Subject: Executors of N Alington – Little Barford Estate – A428
From: Bidwells
Date: 17/02/2022

SUMMARY OF COMMENTARY AND REPRESENTATIONS AND CONCLUSION OF POSITION STATEMENT ON BEHALF OF THE LANDOWNER

Figure 8 – A428 bridge proposal

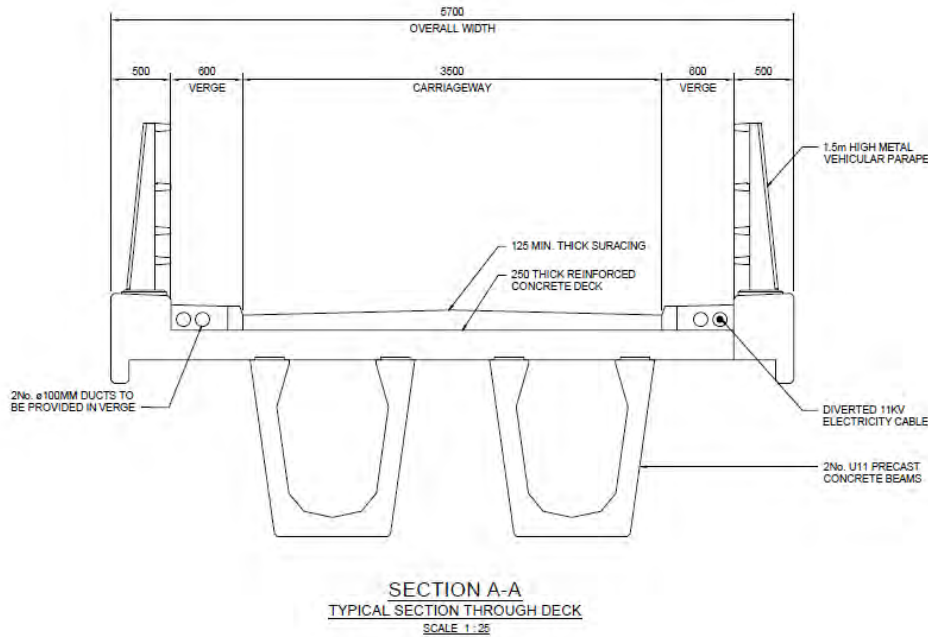
The issue of the width of the bridge has been resolved by agreeing that there will be a minimum clearance of 6m between the fence and parapets of the bridge, so as to give sufficient safe access for machinery of 6m wide. Please note, this may require a slightly larger width than 6m in order to give a safe working width.

3. The overbridge matter has been agreed in principle, with a bridge of sufficient width to enable safe clearance for 6m wide machinery.
4. The Executors maintain the objection to the location of a block of woodland to the west of the A428 on the grounds that a similar, if not better, ecological result could meet the mitigation objectives, which could be achieved by locating this woodland adjacent to existing wood. The Executors would be willing to grant to rights to do this.

TEMPORARY AND PERMANENT LAND TAKE

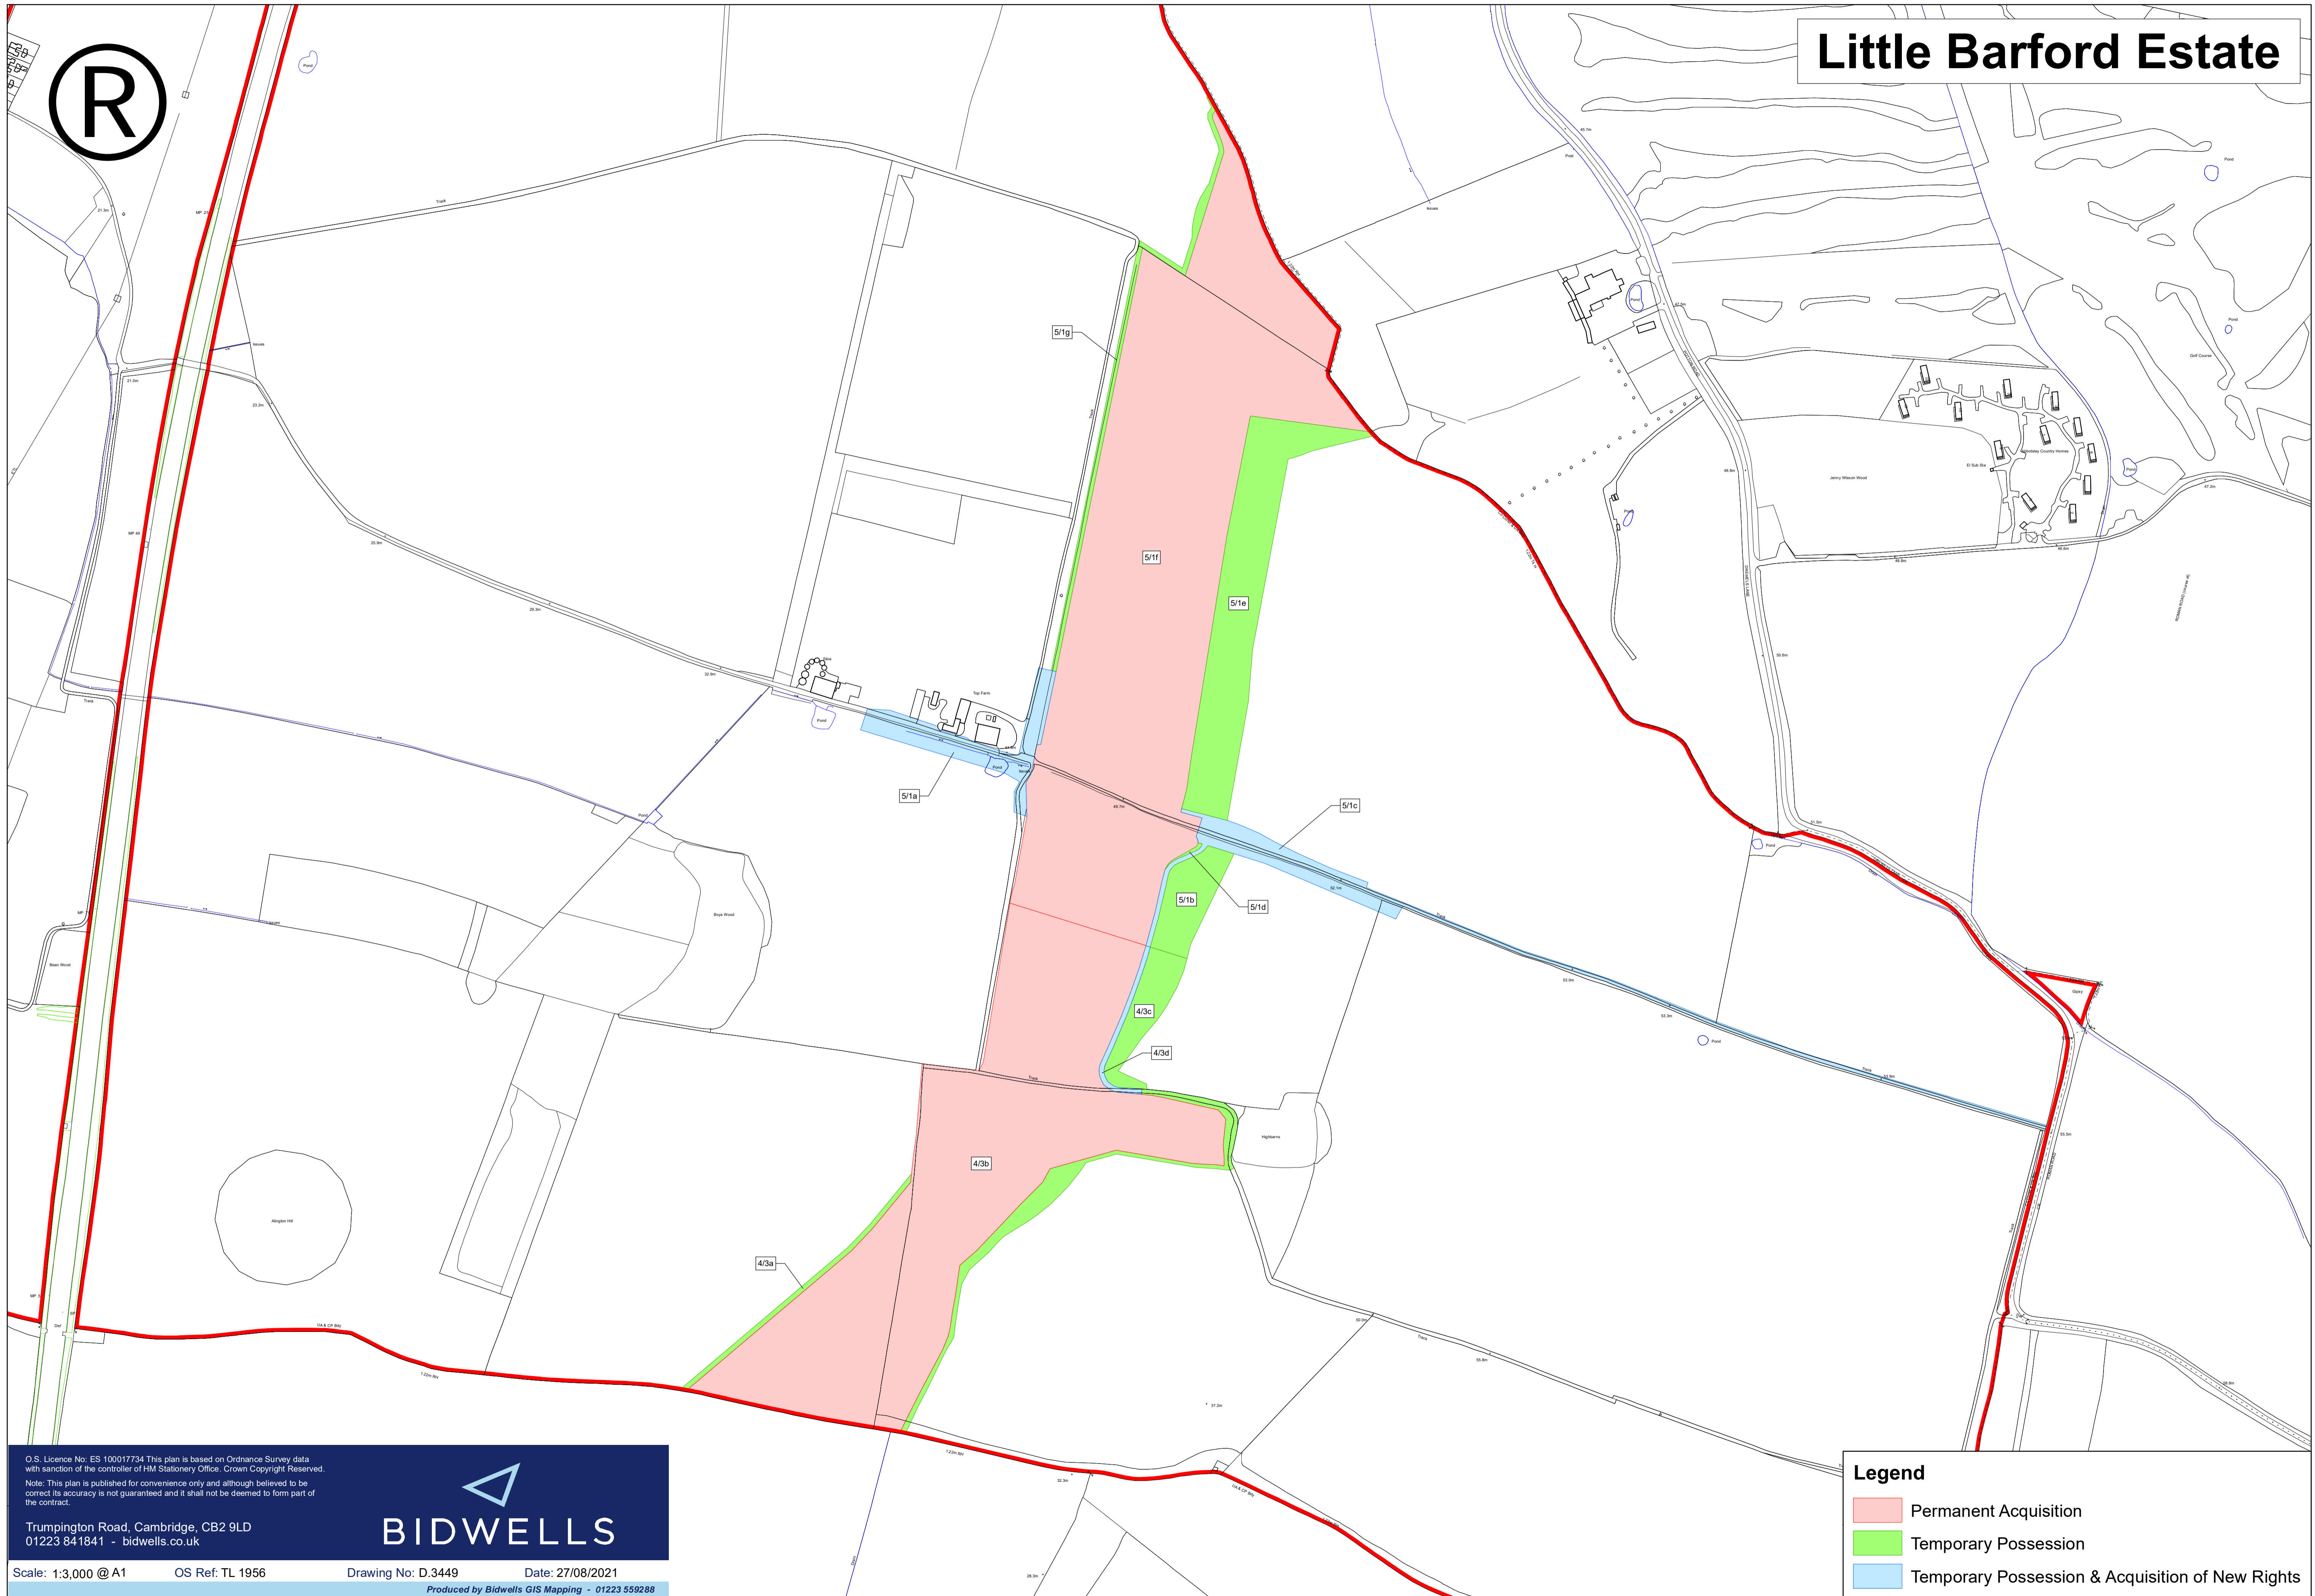
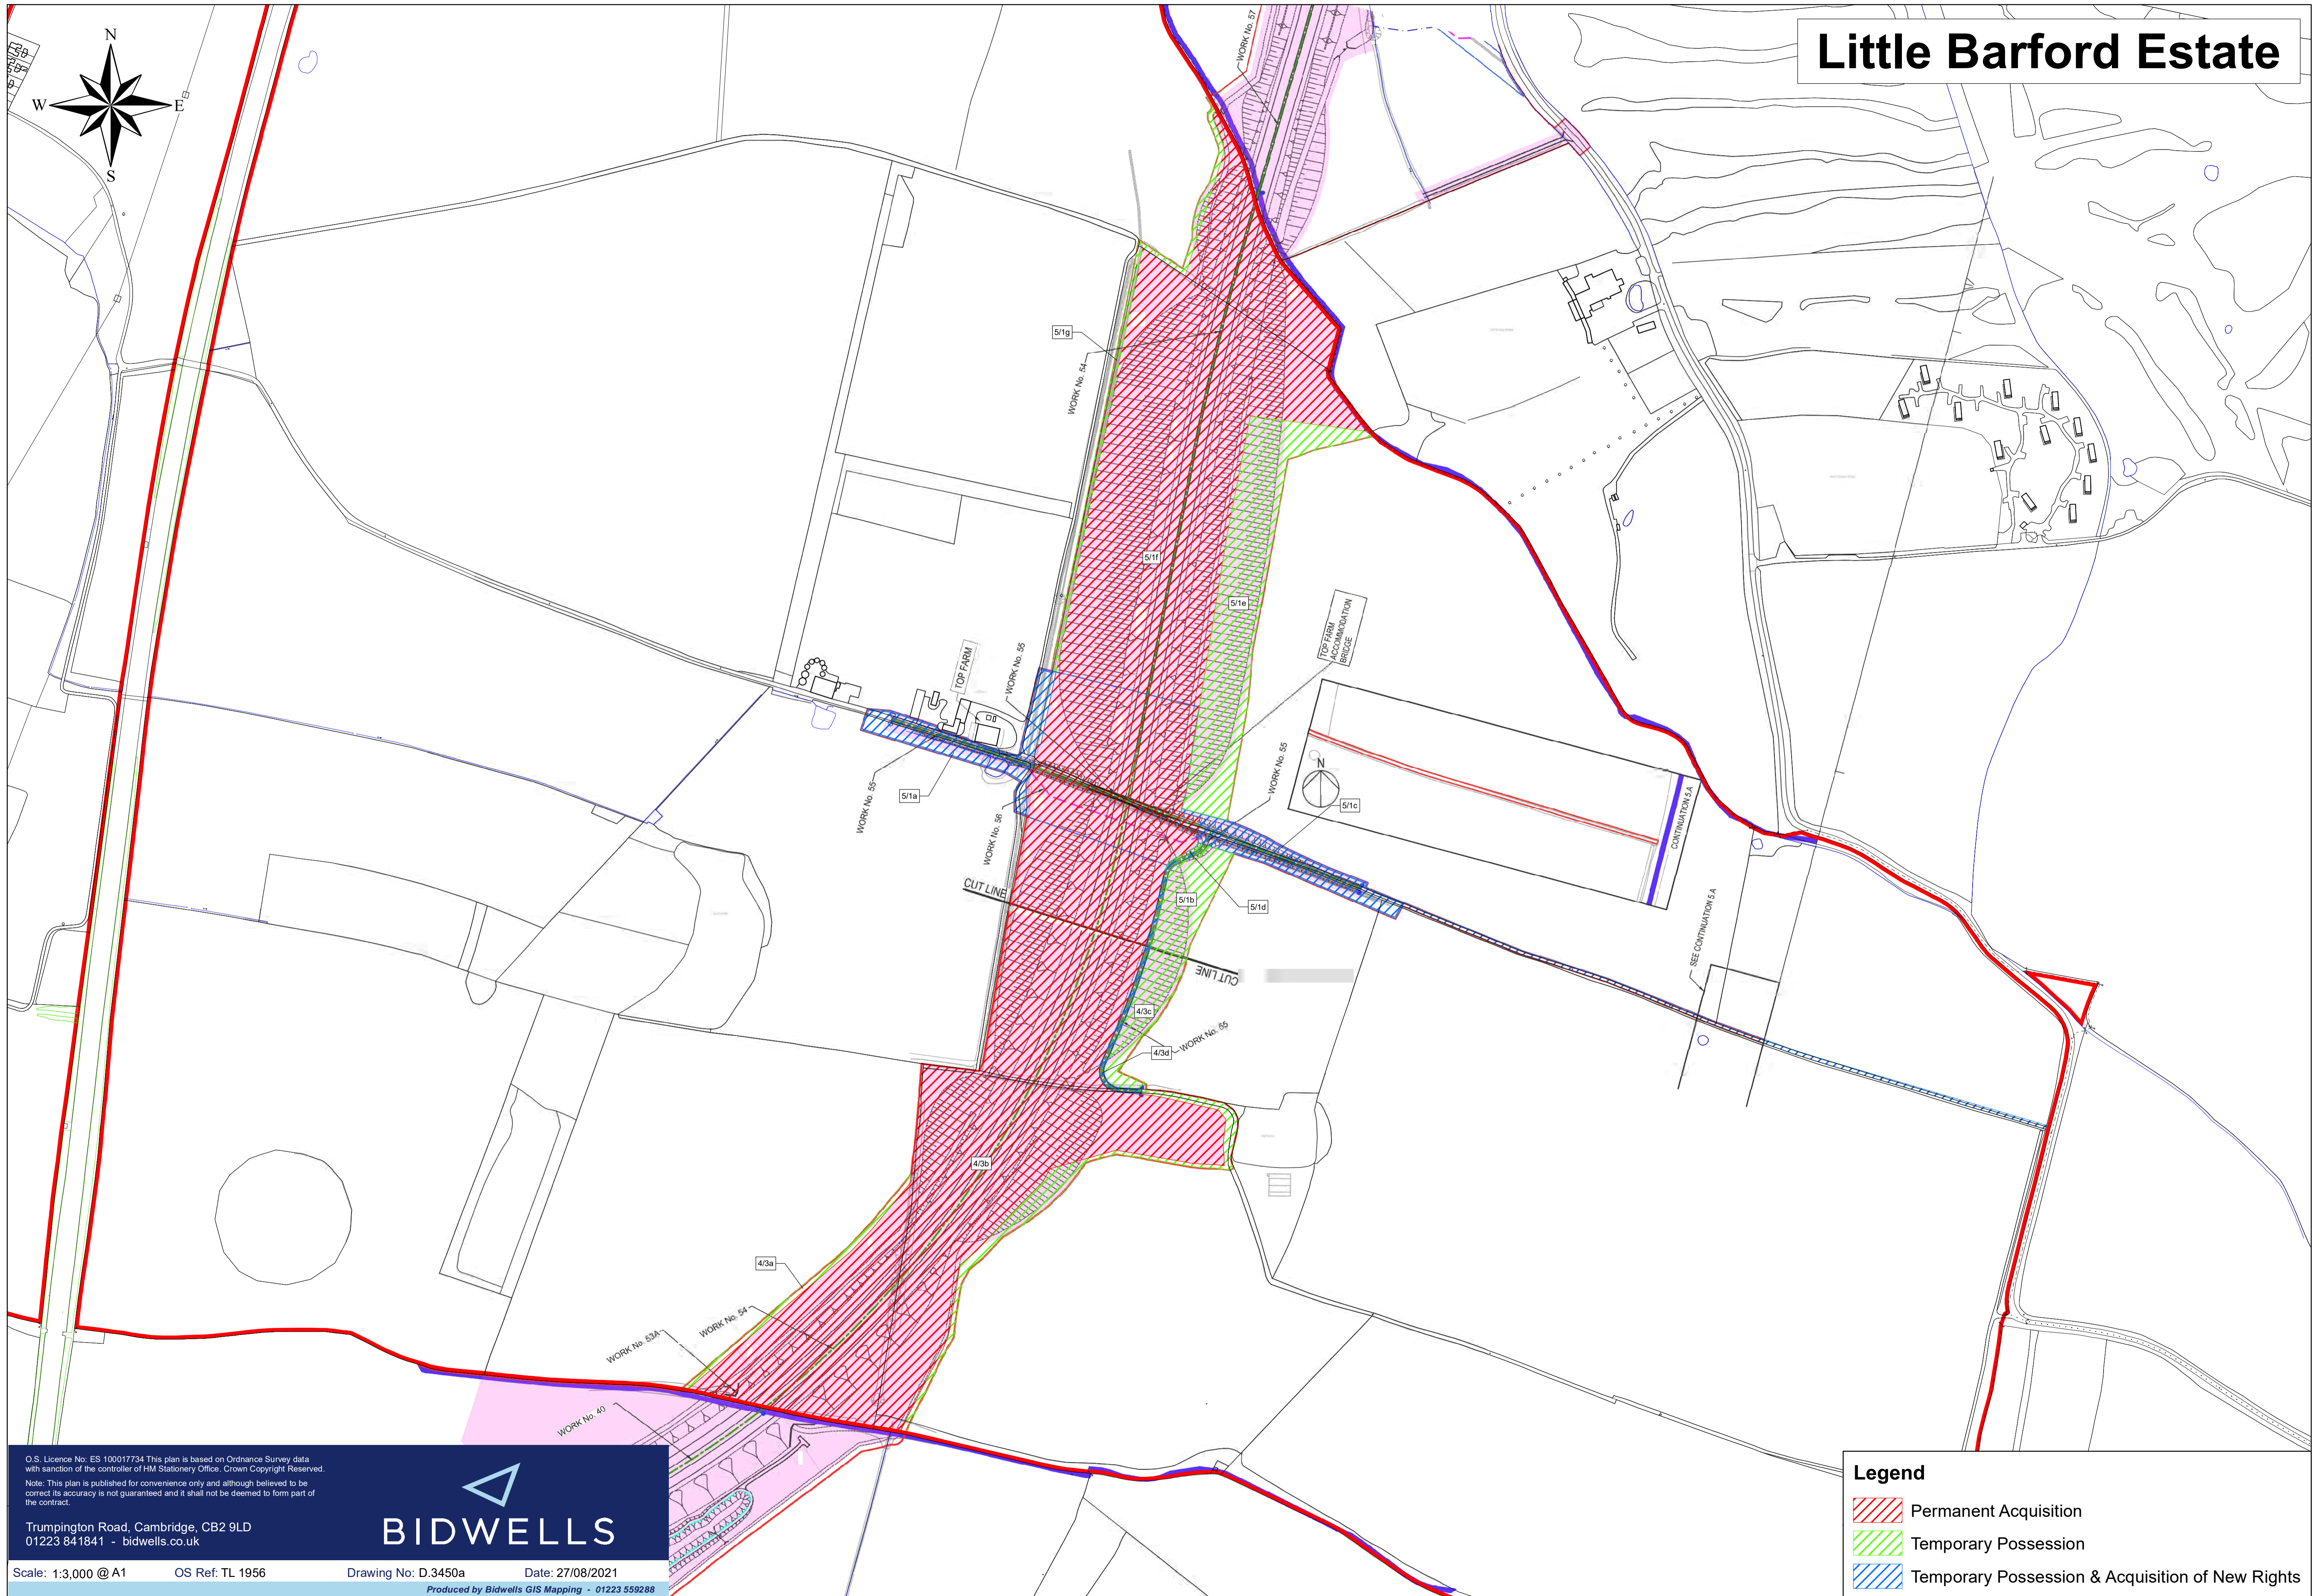
The applicant is seeking a wide range of powers in addition to the proposed land take procedure, including the ability to vary alignment within a margin for deviation. The Executors object to these on the grounds that:

- a) The permanent land take is excessive; and
- b) The ability to take further land as yet unspecified and the proposed means by which land may be taken or returned are inappropriate.

2. The extent of land being permanently acquired is excessive. Furthermore, the procedure which is intended to be through the GVD route, and the powers granted to the acquiring Authority to vary alignments without producing a precise design drawing prior to acquisition, is inappropriate and will lead to difficulties in concluding a claim. The Crichel Down procedure, as operated by National Highways, is inappropriate for dealing with land return.
